The Shire at Old Ranch

CS - EC - I
Erosion Control
Plan

County File No. PPR2410

EC-1  
Erosion Control Plan

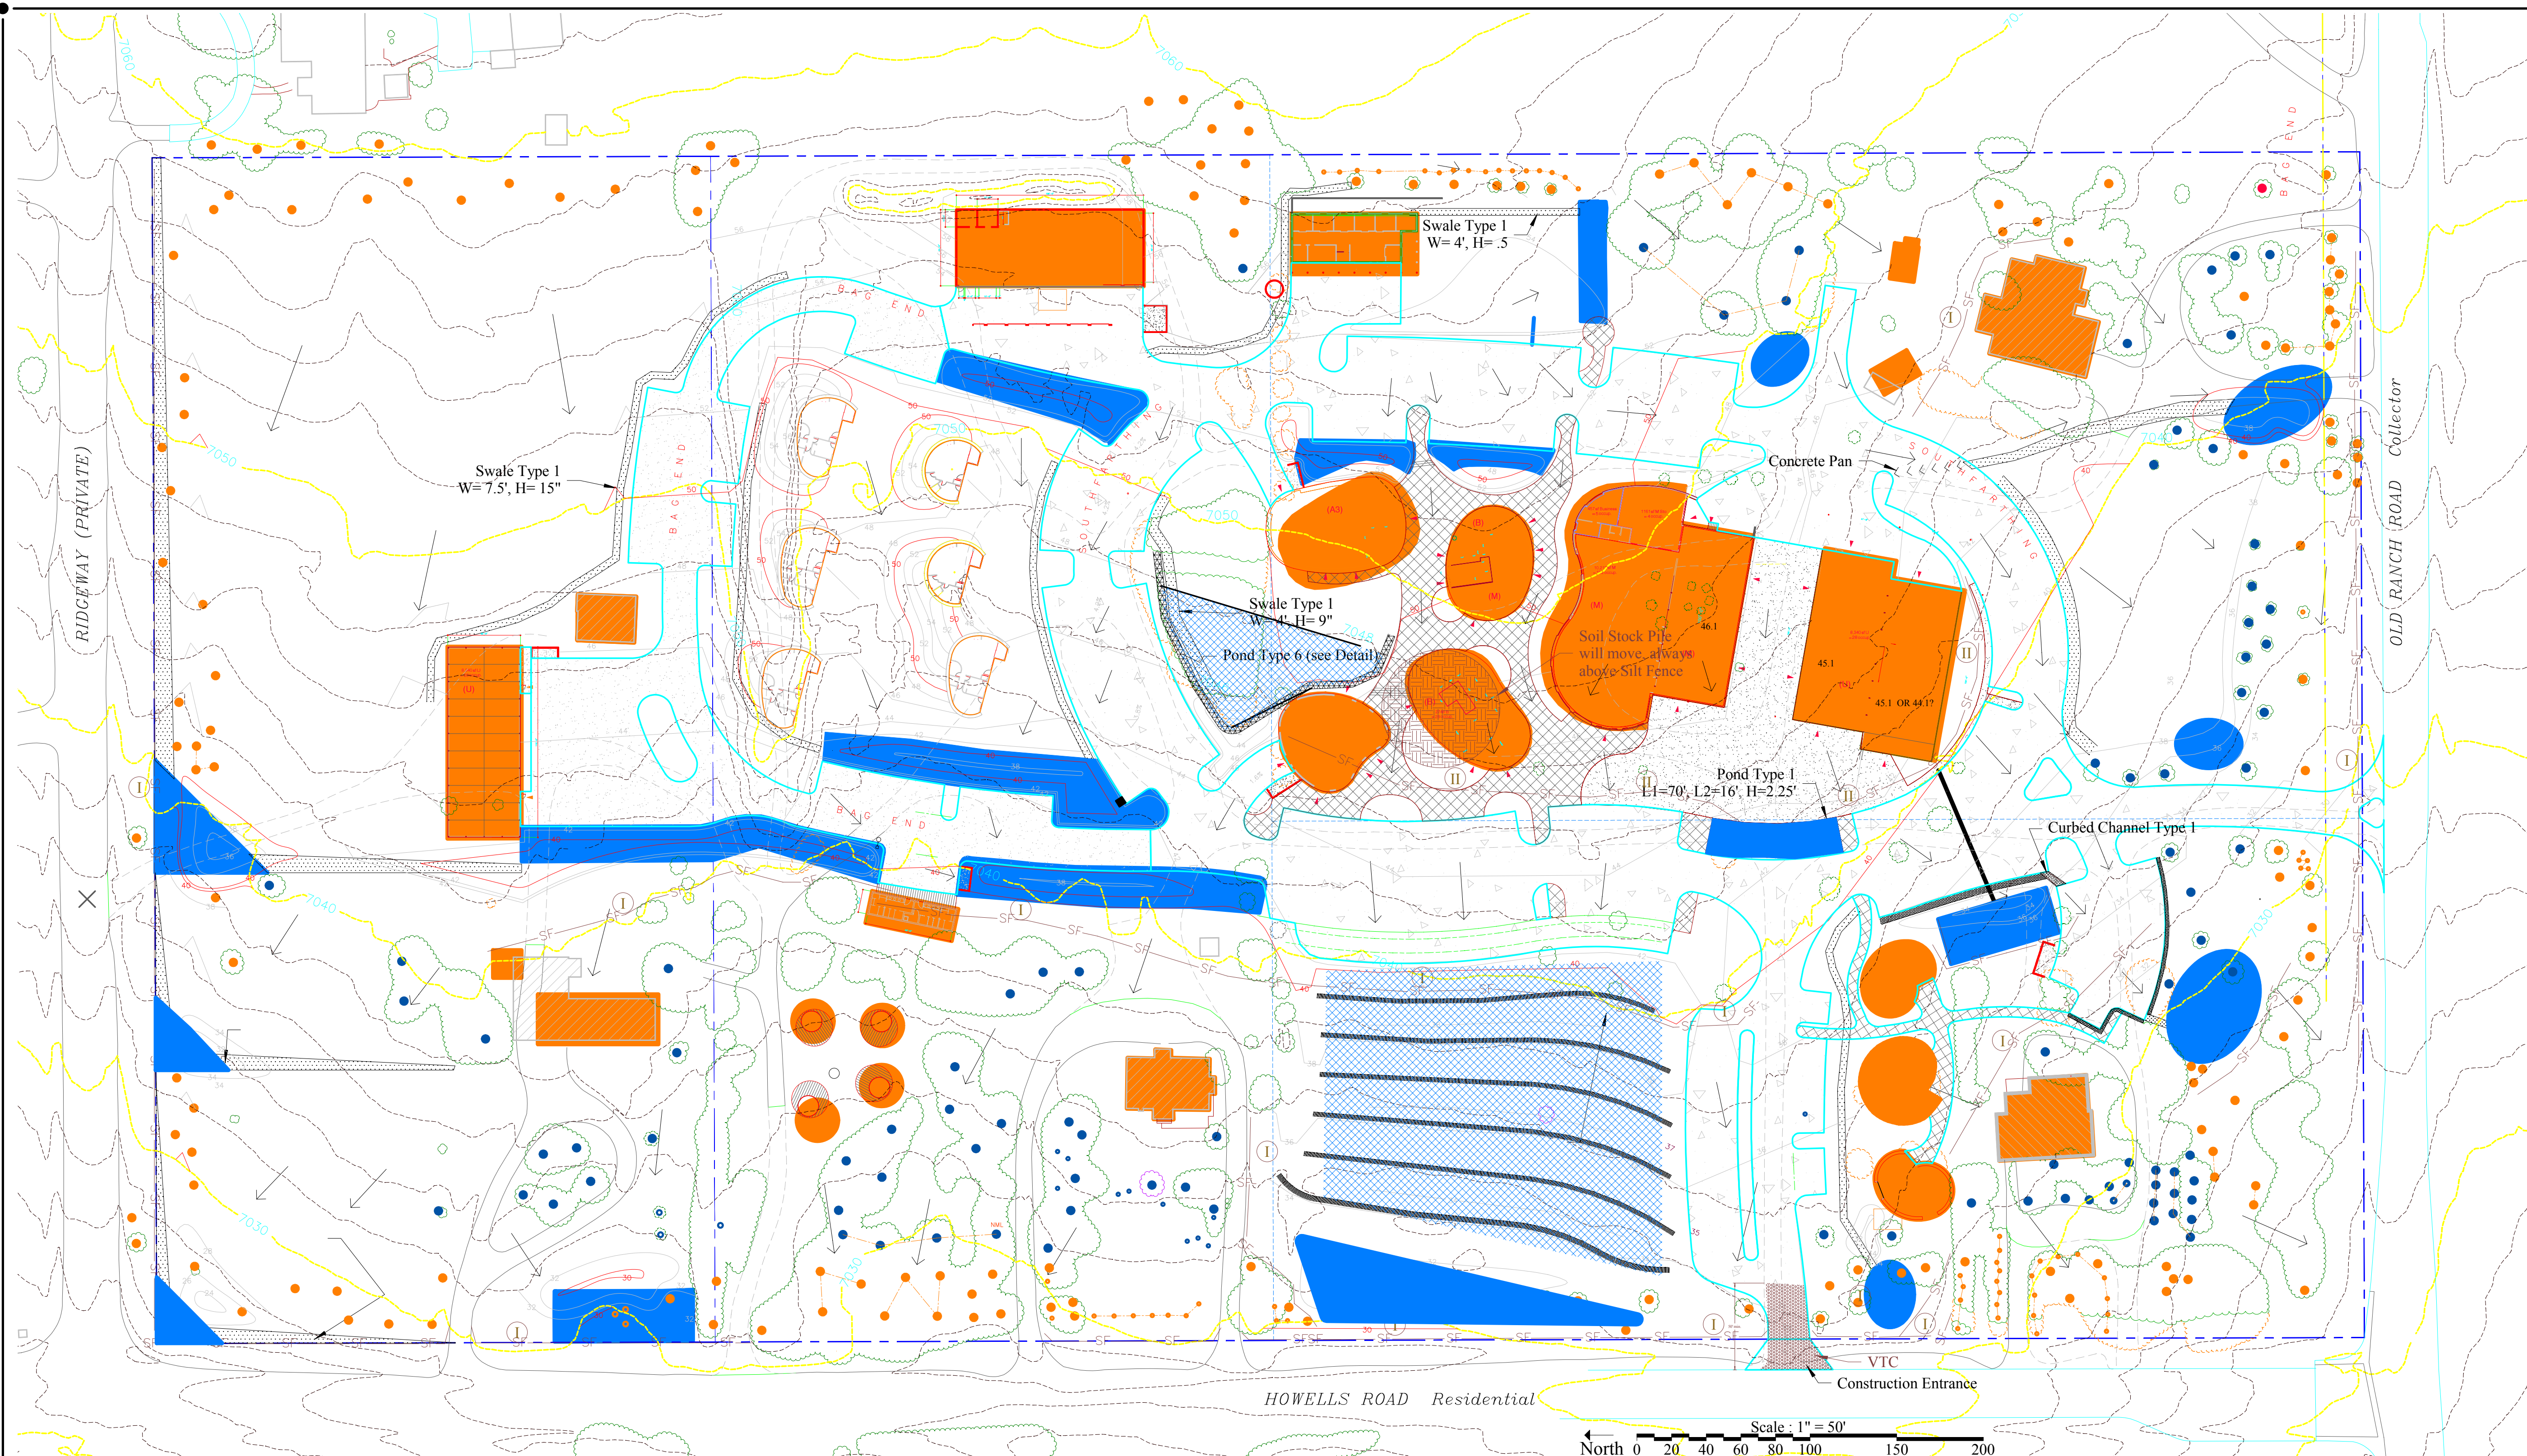
Unresolved: Final control measures should list all final measure ie infiltration ponds and seeding/mulching. Put these BMPs in the initial or intermediate section so it is clear when they should be constructed.
